Re: Holly Cottage, Court DriveHarry Nar <hnar@hillingdon.gov.uk>

Case ref ENF/201/16 now closed.

Accordingly, the roof extensions (rear dormer facing 31 Court Drive and the enlarged front dormer and new dormer facing 35 Court Drive) appear to be covered by Class B.1(c) of the General Permitted Development Order (GPDO). However, the

Revisions
Drawing Title
Existing Floor Plans & Elevations

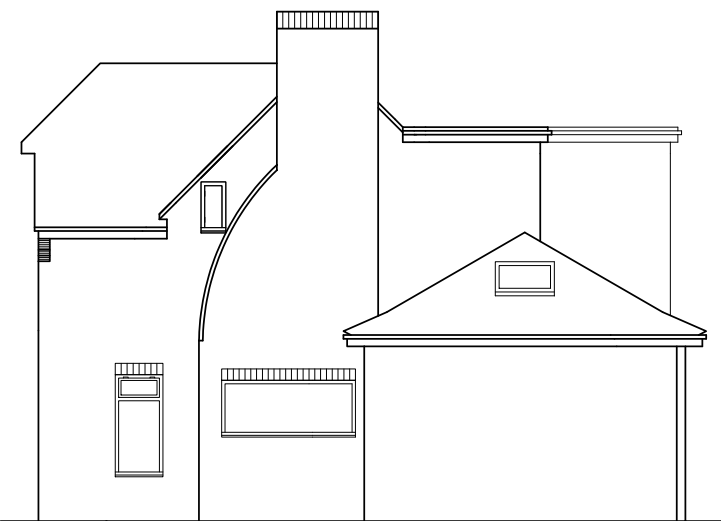
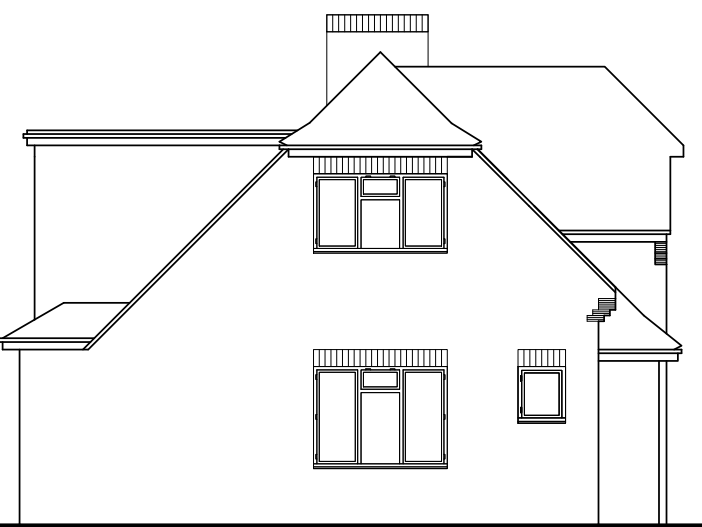
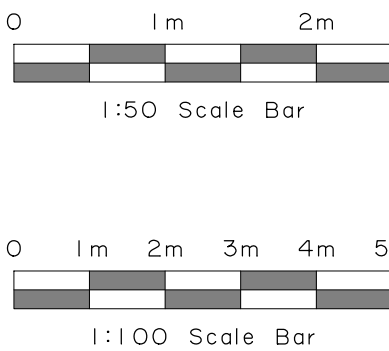
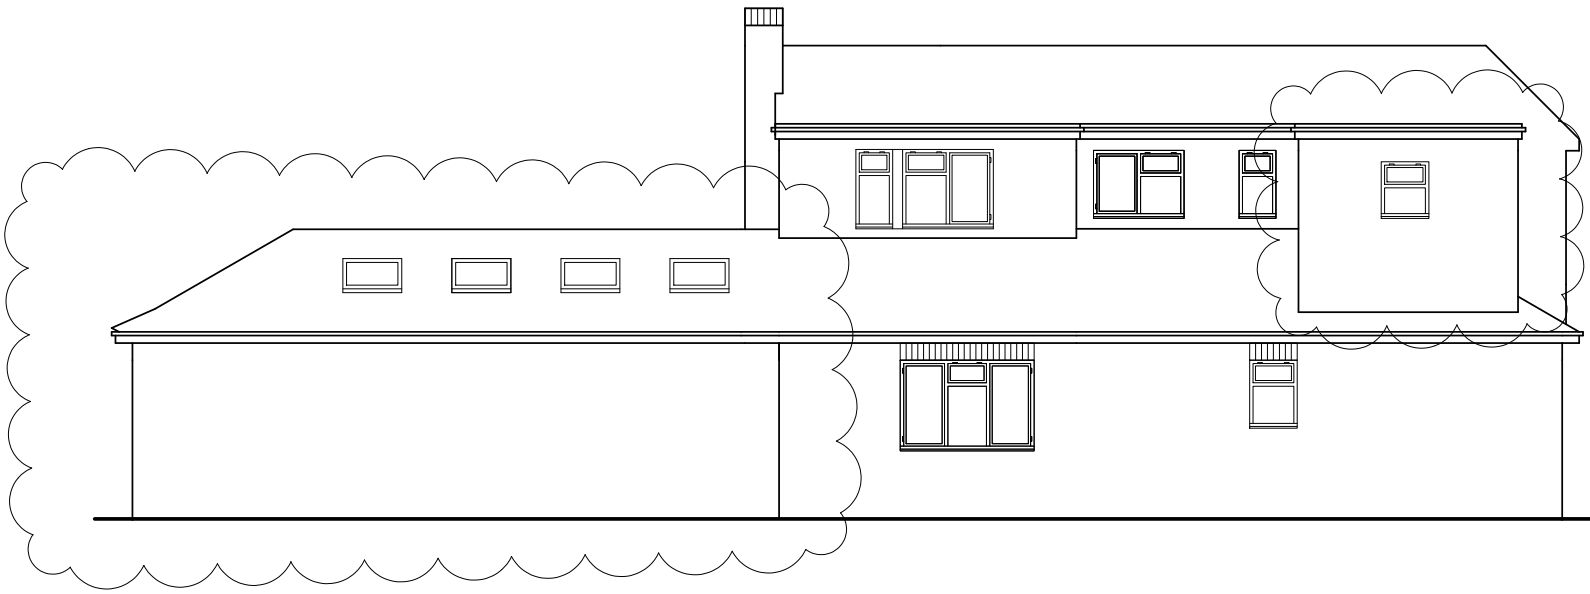
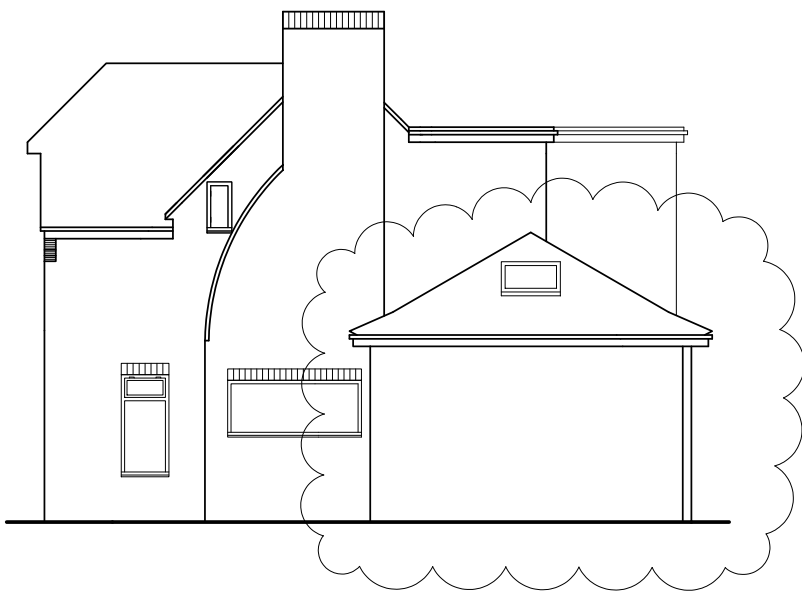
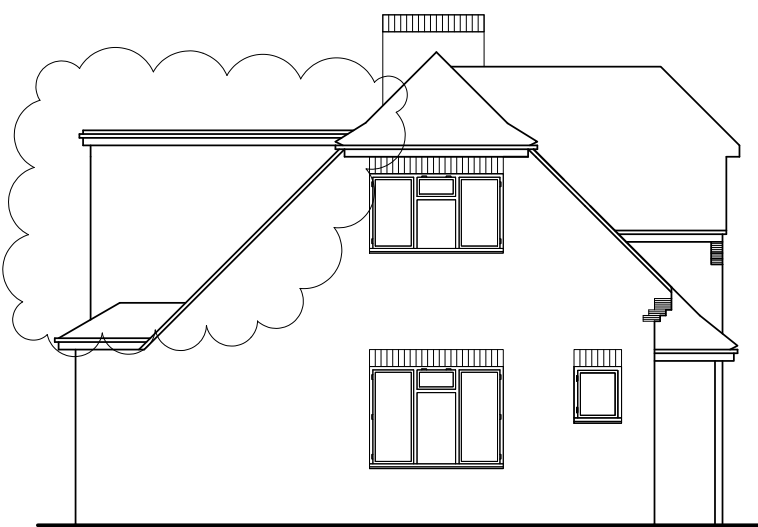
Due to the character, layout and orientation of your property identifying the "principal elevation" of your property this was more complex than normal. However, I can confirm that following my site inspections and earlier telephone conversation with you, it appears that the principal elevation of the dwellinghouse does not front the highway.

Council have yet to determine if the cubic content of the resulting roof space is within 50 cubic metres; as conditioned by Class B.1 (d) (ii) of the GPDO.

Therefore, you are requested to provide elevation drawings with the calculation showing the additional roof space created by the roof extensions to the Council for determination.
